Application number: 2025/92242	
What is the application for?:	Reserved matters application (including consideration of appearance, scale and l
Address of the site or building:	Land off, Hermitage Park, Lepton, Huddersfield, HD8 0JU
Postcode:	WF2 7UA

User comments

Drawing Title					
Tree Protection Plan 1 of 2					
Drawn	Checked	Scale	Rev	Rev	Date
DR	MS	1:500	NA	NA	10/24
Drawing Status		Rev.		SP Project No	
Planning		1		21376	
Project No.	Originator	Volume	Level	Type	Role
21376	SFH	XX	XX	DR	L
Number					
TPP01

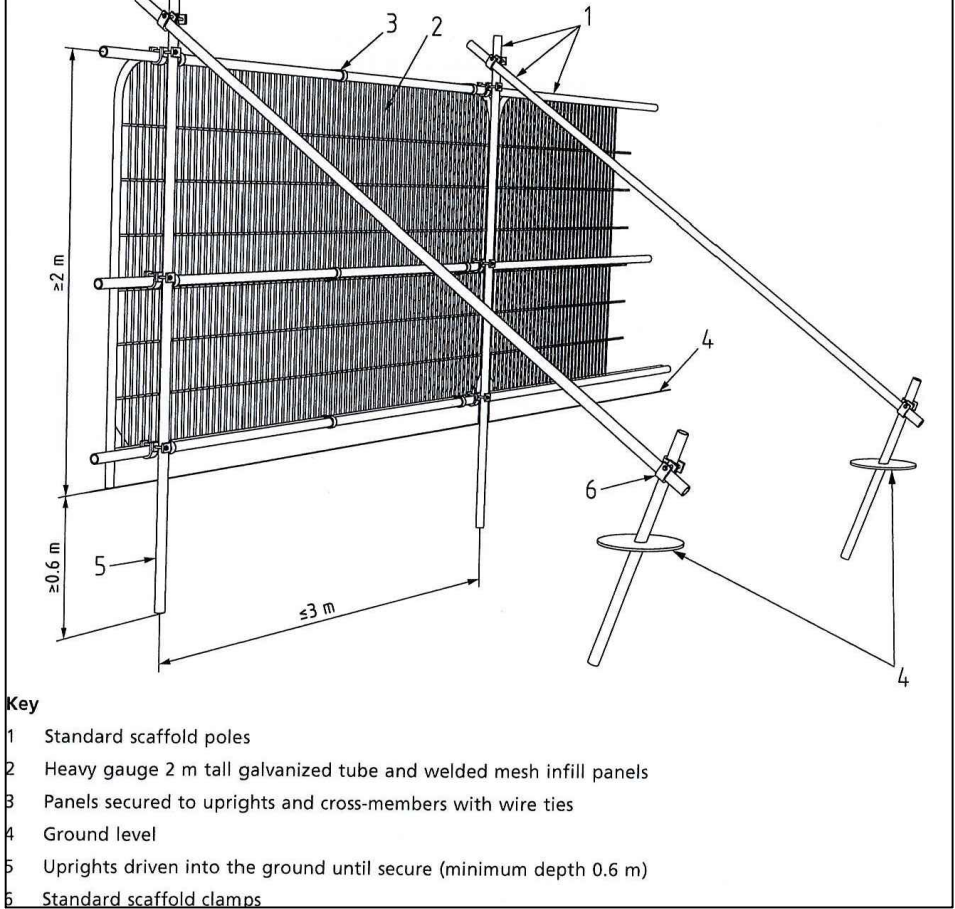
Type of comment: An objection	
Do you wish your comments to be published on the website anonymously?	Yes
As Chair of the Upper Dearne Woodlands Conservation Group, I would like to express the Group's concerns as to the risk to the ancient woodland which borders this development. We understand that the standard 15m 'quarantine' boundary is proposed between woodland and housing. This is allied to no attempt being made to make good the woodland wall boundary. We regard these proposals as ecologically damaging in that they encourage increased human footfall across the woods and the 15 metre quarantine provides insufficient protection to the tree cover. The range of species in these woodlands is itself ecologically and historically significant, reflecting a pattern which dates back to Lepton's founding as a medieval township. and deserving the maximum protection which can be afforded
